Consultee Comment for planning application 6/2018/2338/FULL

| Application Number | <input type="text" value="6/2018/2338/FULL"/> |
| Proposal | <input type="text" value="Installation of 2 Electric Vehicle Charging Points alongside 2 existing car parking spaces, with ancillary bollards, signage posts and power feeder pillar"/> |

Drawing Title			
PROPOSED CHARGING POINTS CHARGER - TYPE 2 PLANS & ELEVATIONS			
<b>TYPE 2</b>	Drawing Number	Revision	
	Plan 3	A	
Drawn	Checked	Scale	Date
PCC/PDSI	SW	N/A	03/09/18

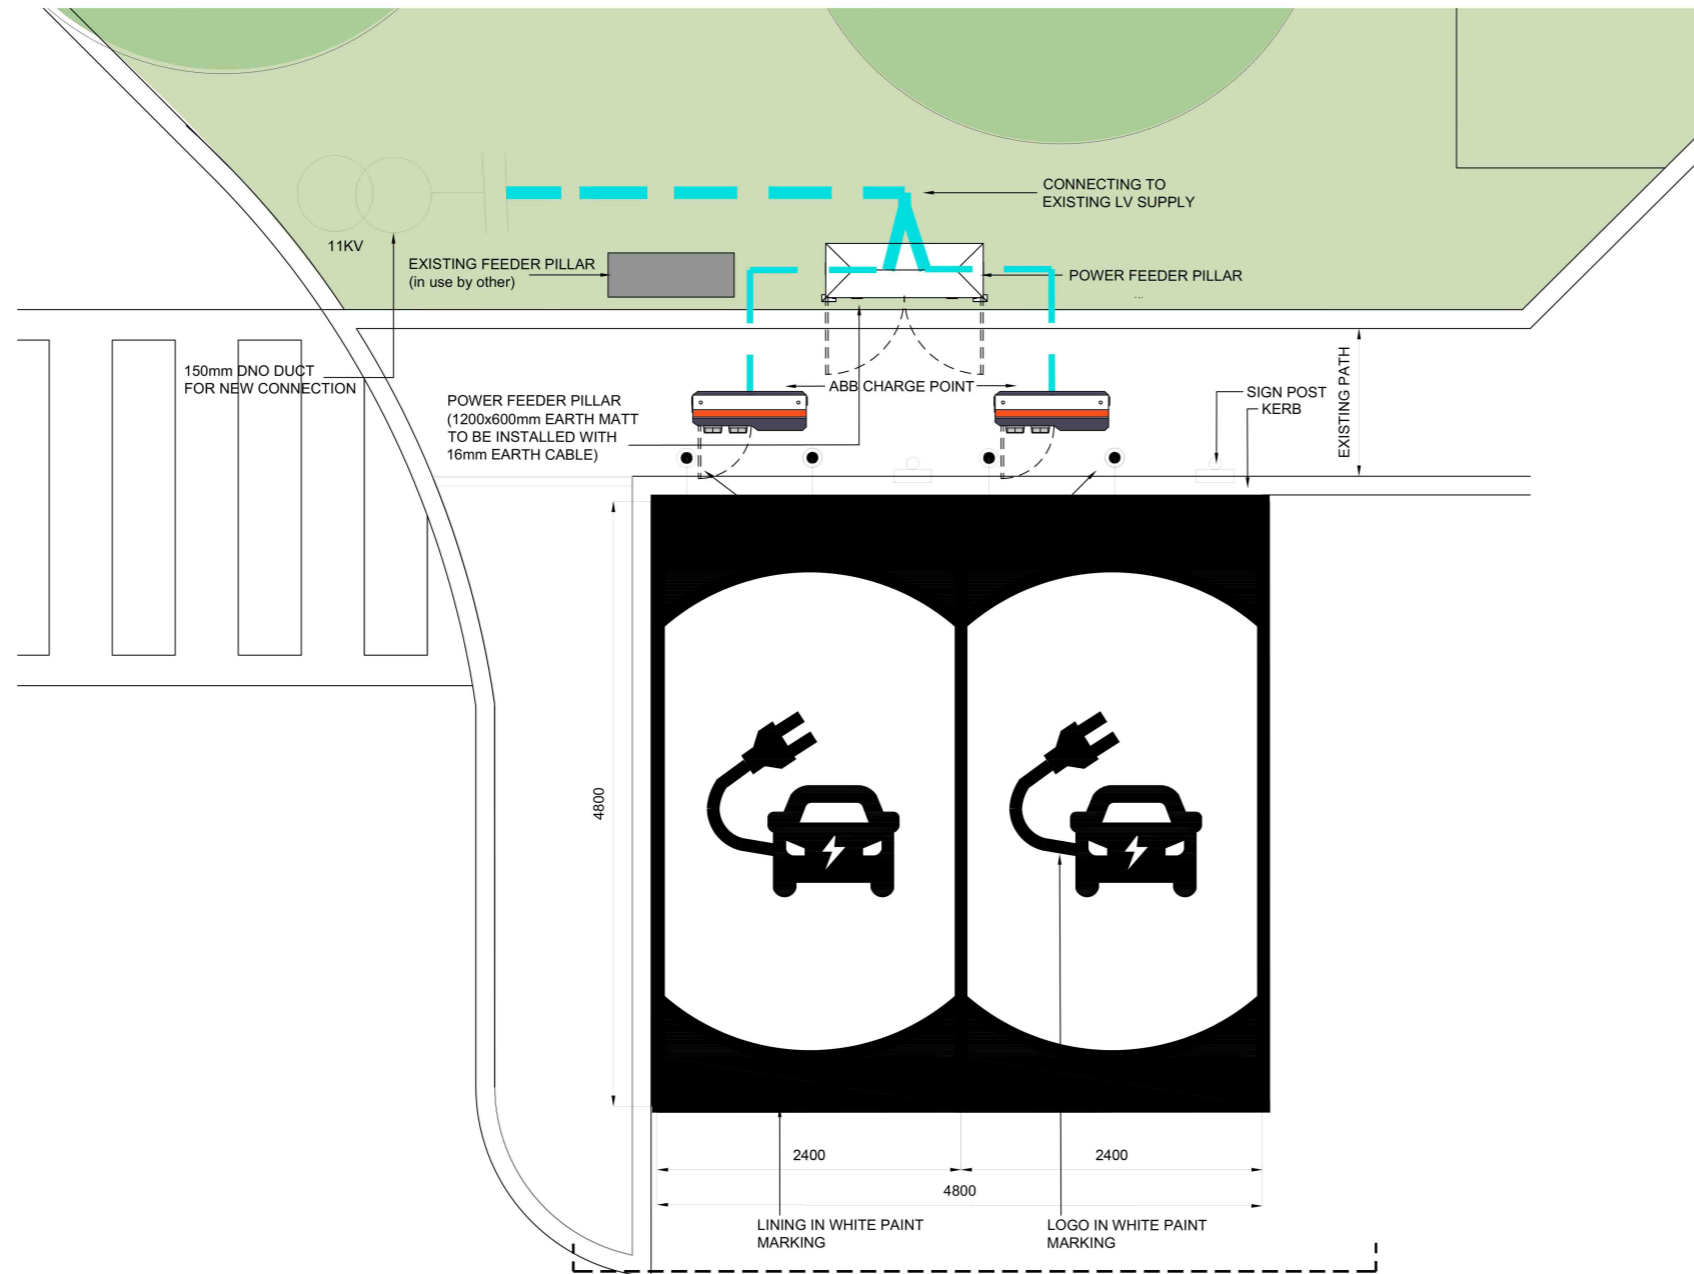
| Comments | <input type="text" value="I welcome more charging points within the borough, as this will encourage people to convert to fully electric or hybrid vehicles when the look to purchase their next car. My only question is, what will happen if non-electic vehicles are parked within these bays, how will this be managed?"/> |
